From: Laura Gibbons
Sent: 18 April 2018 12:09
To: Planning.Responses
Subject: RE: Planning Consultation on R/66/18/DOC

APPLICATION R/66/18/DOC
NO:

Site Address: Fleur De Lis Station Road Rustington BN16 3BH

Works: planning refernece R/269/15/PL relating to scheme for disposal of surface water drainage

DRAINAGE LAYOUT				
Scale 1:125	Paper Size A1	Date JUNE 2017	Drawn By JH	Checked By CH
Project No. RRL012		Drawing No. 505		Revision P3

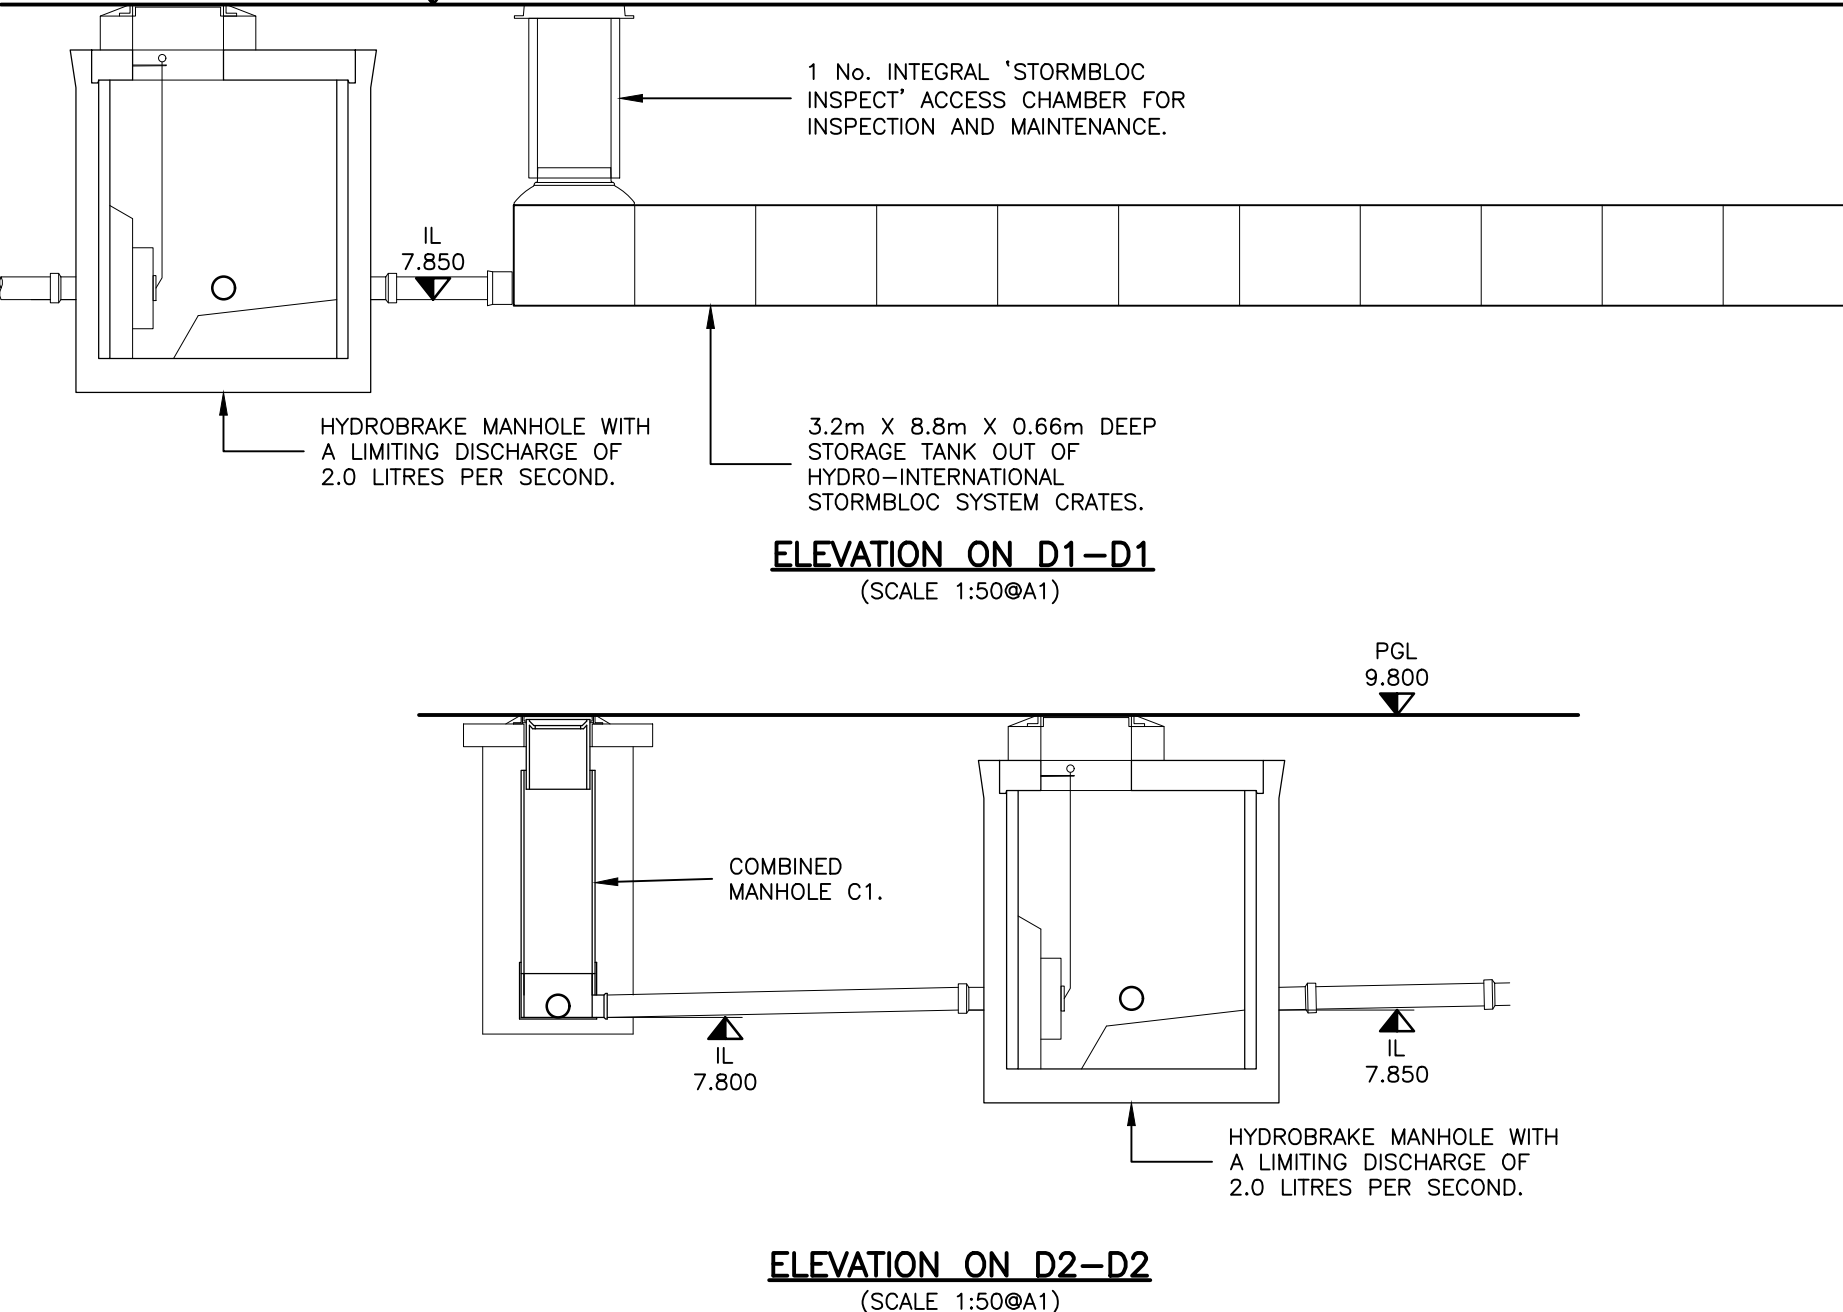
We require proof that groundwater monitoring and winter percolation tests in accordance with BRE365 have been completed. Discharge to the foul sewer is the last option. I have attached our guidance notes for further information.

Test results need to be provided before we can review the proposals.

It would also be beneficial to know where surface water from the previous building went to.
